Subject: BR/215/18/PL 75 Highfield Road

I have now discussed this with senior officers. We consider the changes you have made to be a positive. However, we still have concerns and are unable to recommend the application for approval. The concerns are twofold:

Drg.No. ADS-002-P D

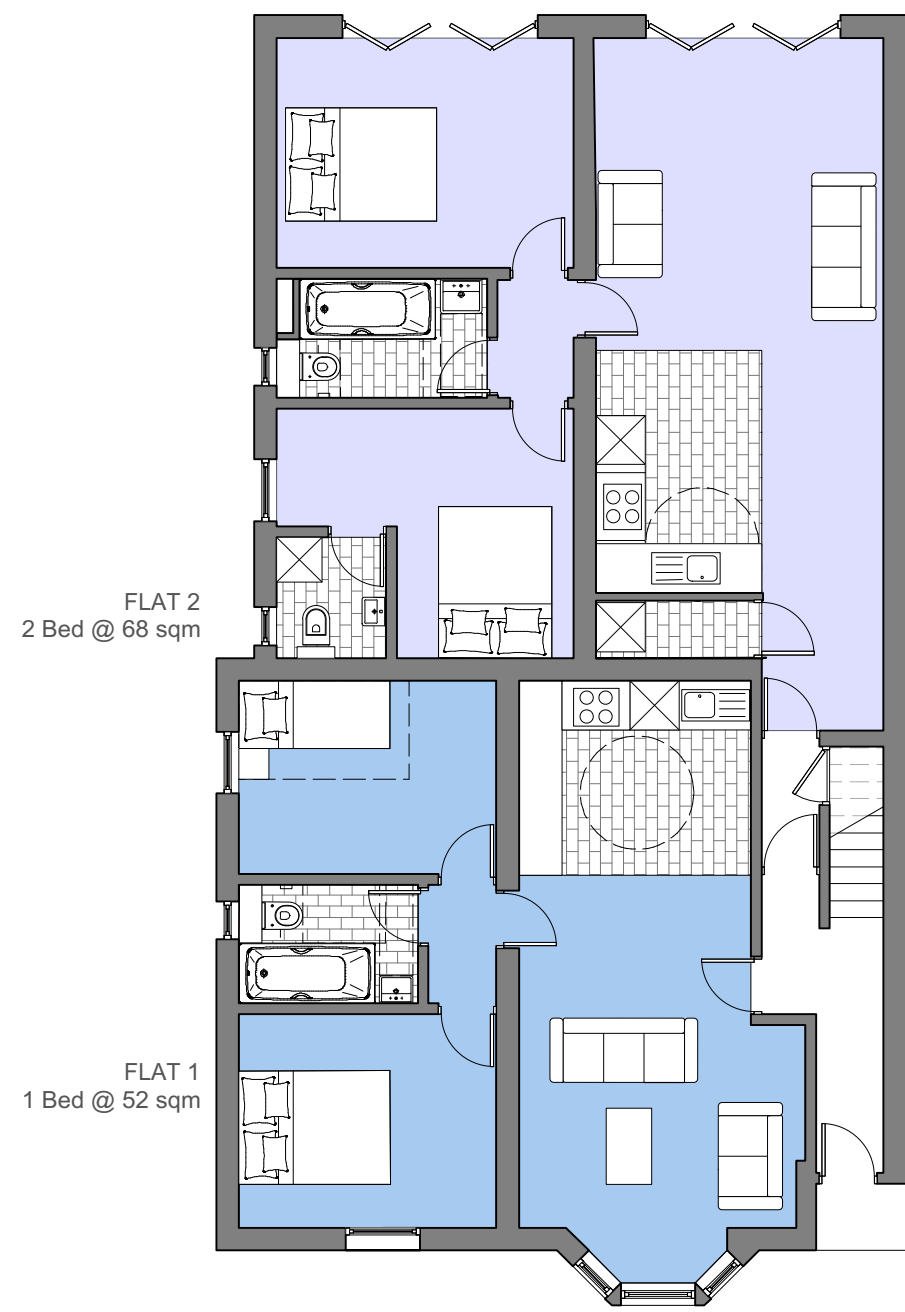
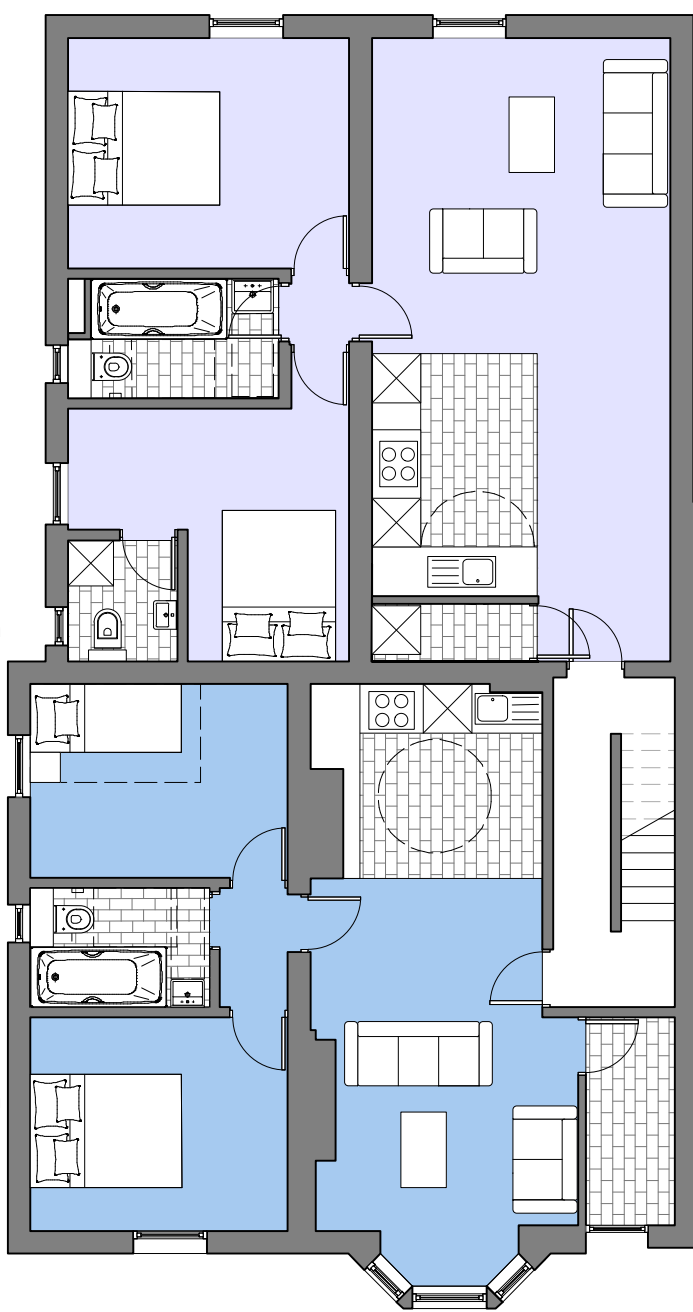
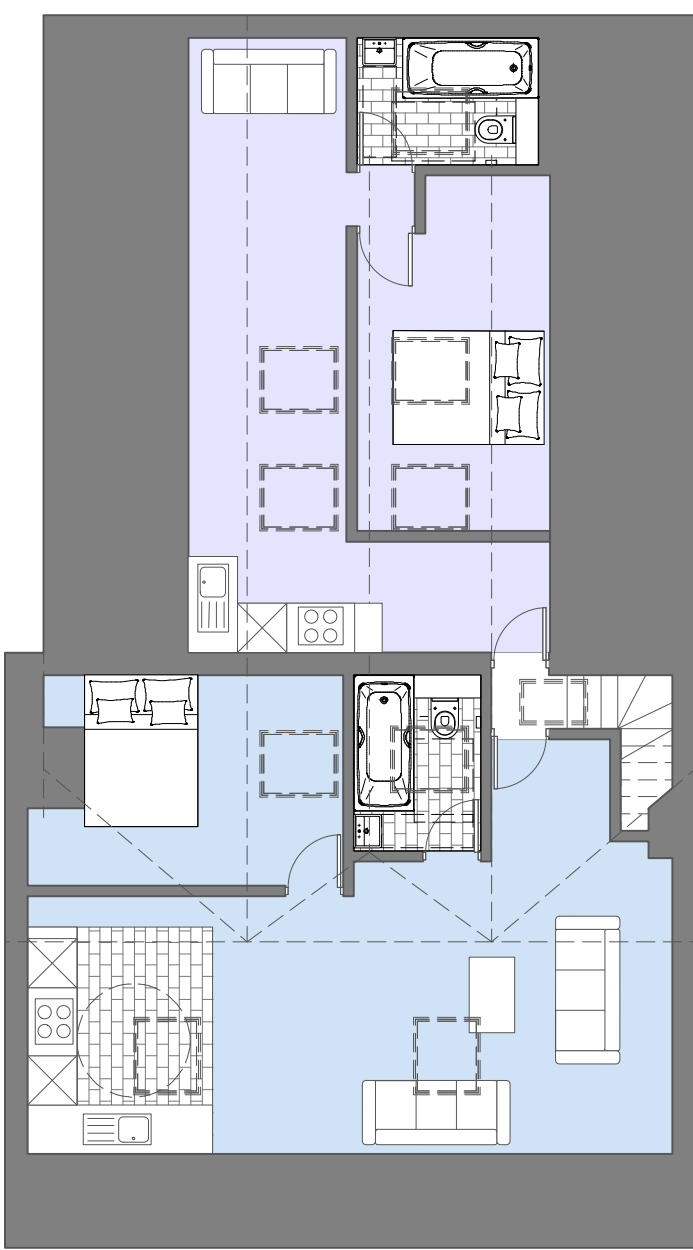
Flat	No. Bedrooms	No. Persons	Requirement m2	Proposed m2 (using your measurements)	Complies?
1	2	3	61	52	N
2	2	4	70	68	N but an acceptable shortfall
3	2	3	61	55	N
4	2	4	70	65	N
5	1	2	50	50	Y
6	1	2	50	39	N

ALP policy D DM2 does allow for some flexibility with conversions and also states that the national space standards are there for guidance only. However, you are failing to get even close to the suggested internal areas on 4 out of the 6 flats.

Our recommendation will therefore be to refuse. You could amend the scheme further to reduce the number of flats (to say 3 or 4 in total) which may resolve our concerns about parking and also ensure compliance with the space standards. However, if you want to go down this route, we would request that the current application be withdrawn and a new one submitted.

Site Plan (Proposed) 1:200

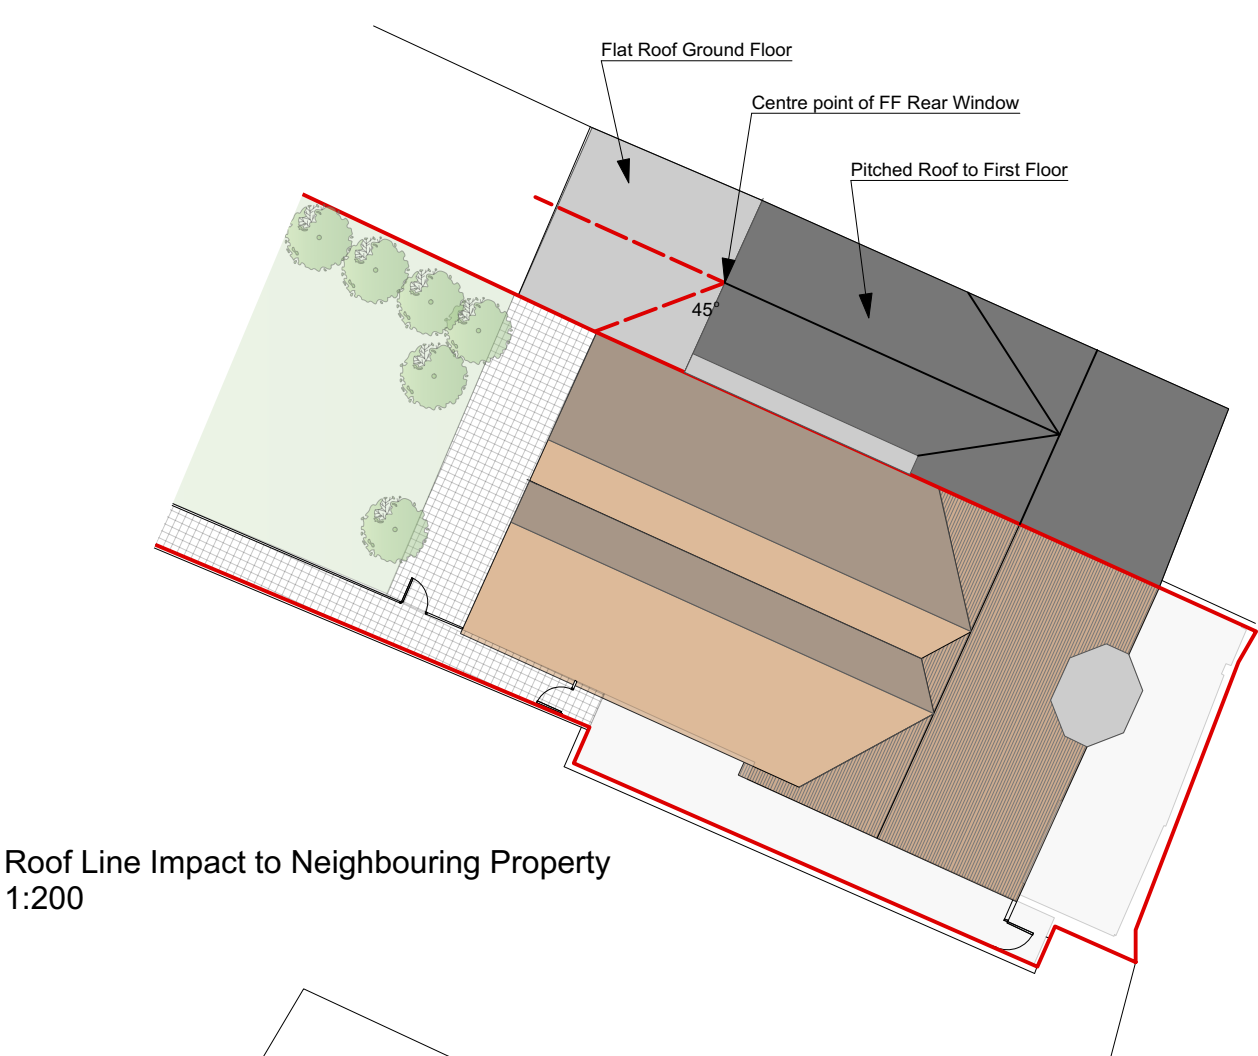
1. Although WSCC have not objected and it is accepted that the site is sustainably located such that a reduced parking provision would be acceptable, we consider that the low ratio of off-street parking to the number of flats coupled with the existing high demand for parking on Highfield Road will result in harm to the amenity of residents. This will be harm in the sense of increased conflict/competition for spaces and/or having to park further away from the person's house. WSCC state that we as the planning authority are allowed to consider amenity impacts such as this.
2. Internal space standards. Please see table below.
